R. G. Lee, P.E.
Lee Engineering
516 Tomasita St. NE
Albuquerque, New Mexico 87123

RE: *Grading and Drainage Plan for Juan Ysido Building (P12/D14) (PWDN-990096)*
Submitted for Grading Permit Approval, Submittal Received May 10, 1999.

SHEET NO.
C-2

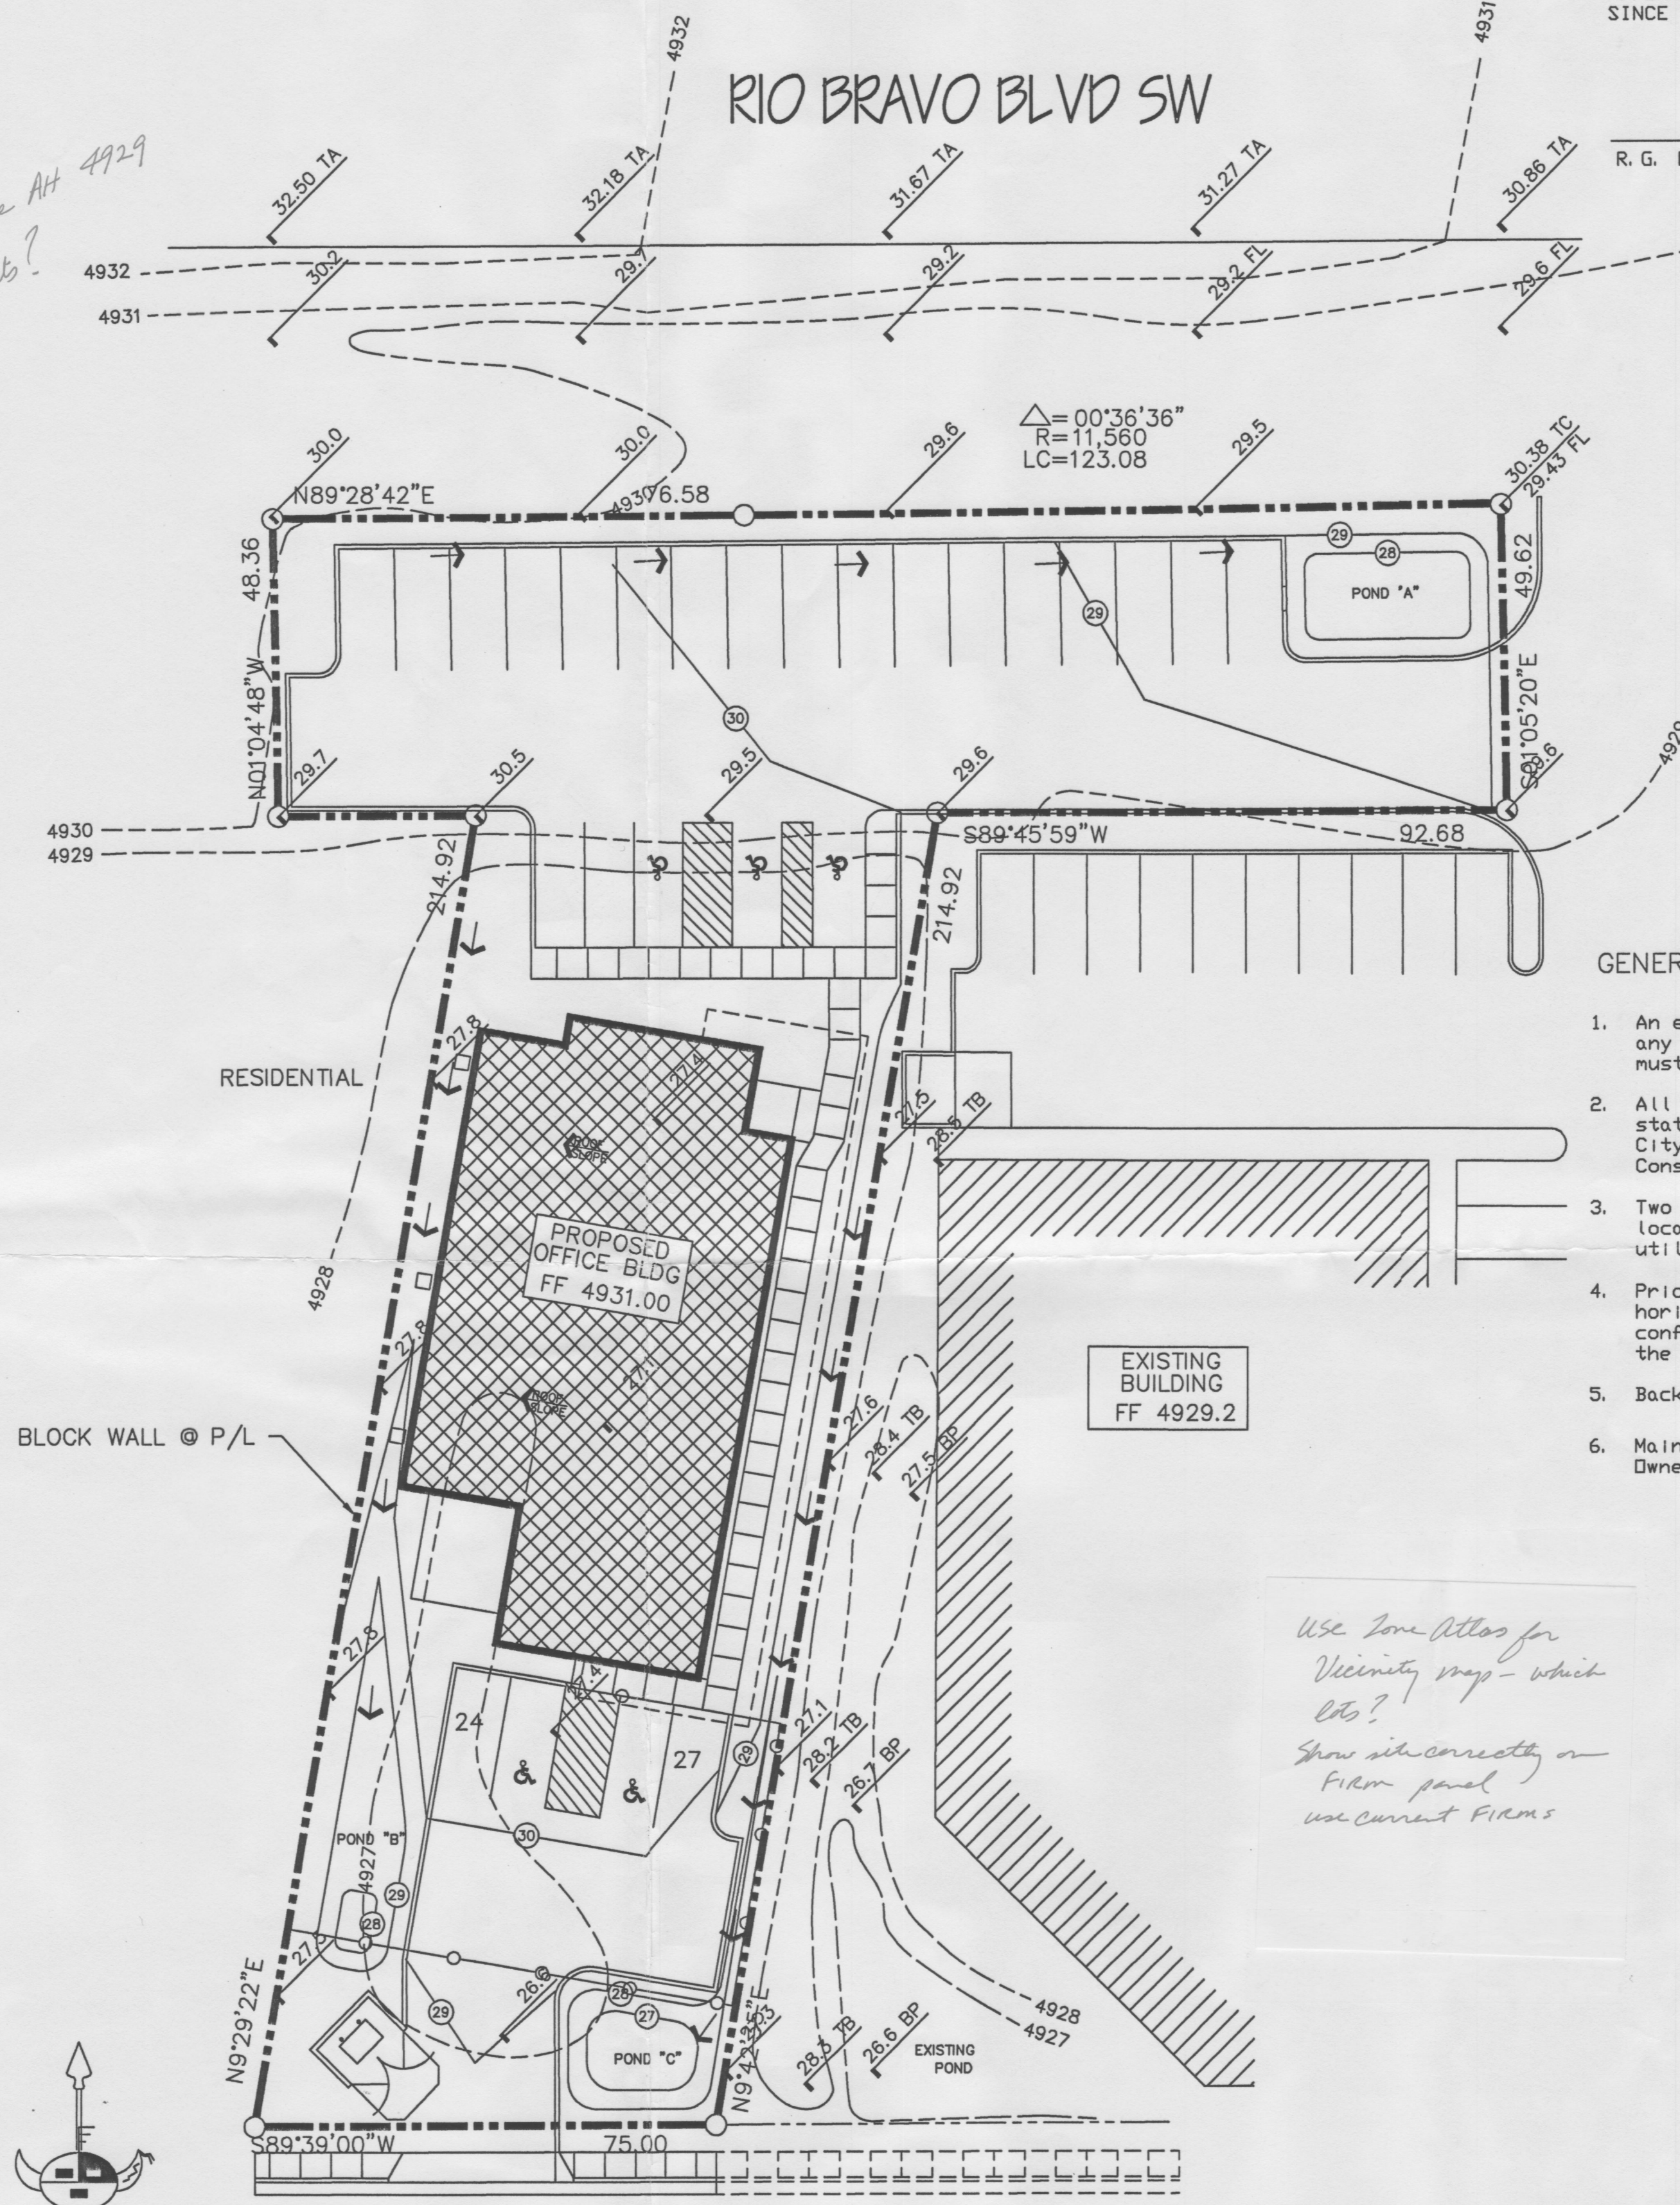
1. Please provide a date by the Engineer's stamp and signature.
2. Regarding the vicinity map, please identify your site on the County Zone Atlas map. It appears that your site boundaries do not match the lot lines shown in the Zone Atlas. Do you propose to replat this site?
3. Please reference the current Flood Insurance Rate Map, and identify the flood zone designation. Identify your site on the current flood map, and show the floodplain limits on the grading plan.
4. It appears that you propose to construct a new office building, however, a Building Permit was not requested. In order to construct the building within the FEMA floodplain, compensatory volume must be provided on the site for the area of the floodplain taken out by the building.
